**Morecambe Offshore Windfarm Generation Assets Development Consent Order
Application Planning Inspectorate Reference: EN010121**

Spirit has reviewed the submissions made by the Applicant at Deadline 1 of the Examination Timetable under the Rule 8 Letter from the Examining Authority dated 30 October 2024 [**PD-010**]. This letter set out Spirit's position at Deadline 2 including comments on the Deadline 1 submissions.

Draft DCO (dDCO) (APP-012) Schedule 3 Protective provisions

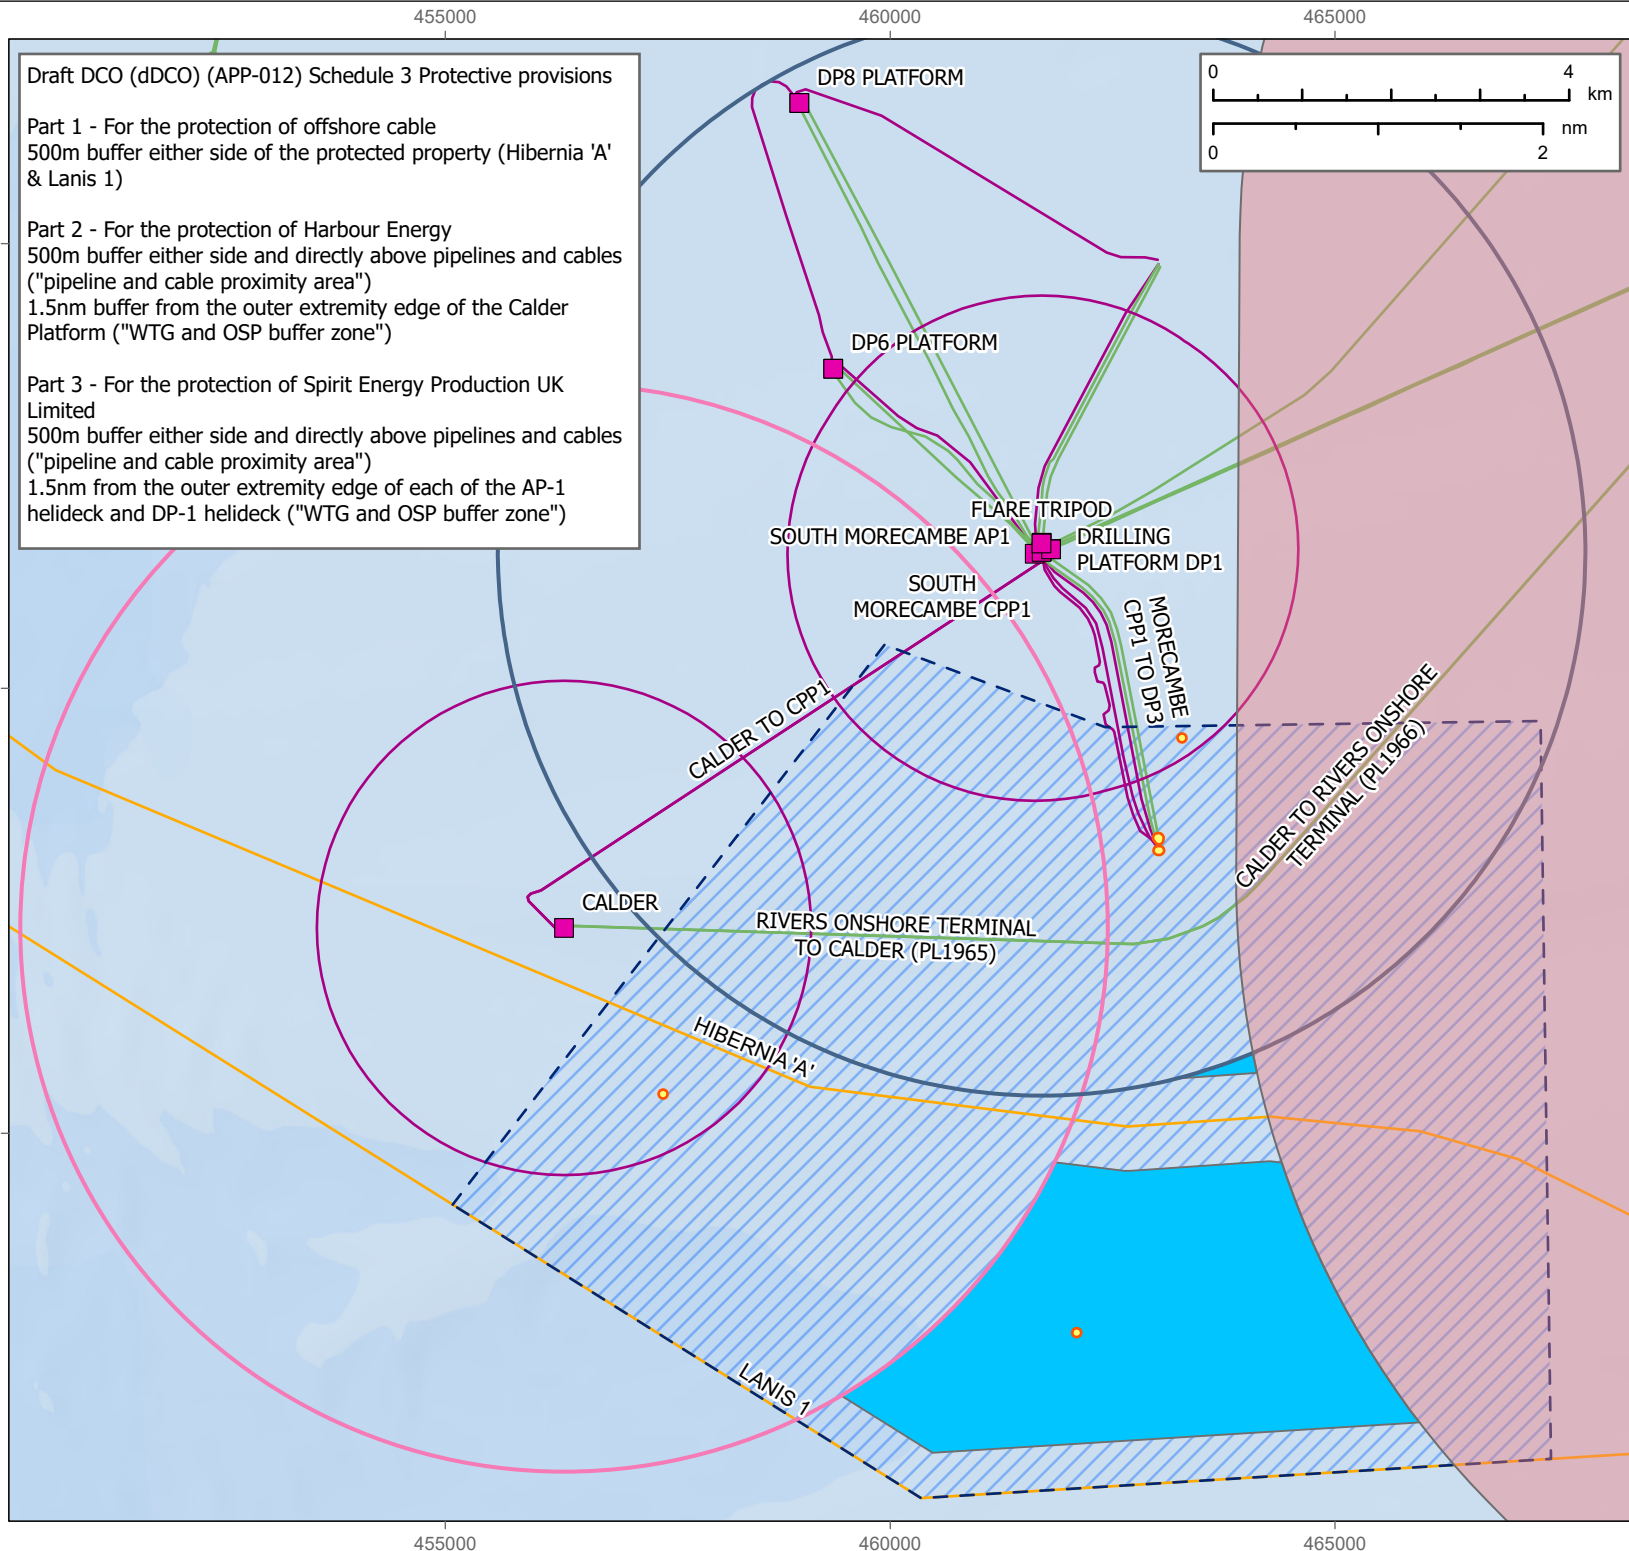
Figure 7.2 "Proposed Buffers from Relevant Representations" enclosed at electronic page 43 of the Response to Actions arising from Preliminary Meeting and Issue Specific Hearing 1 [REP1-086] identifies a 3.3nm buffer around the South Morecambe CPP1. Spirit refers to and reserves its position as set out in paragraphs 2.9-2.22 of its Written Representation [REP1-116], requiring a buffer of at least 3.9nm.
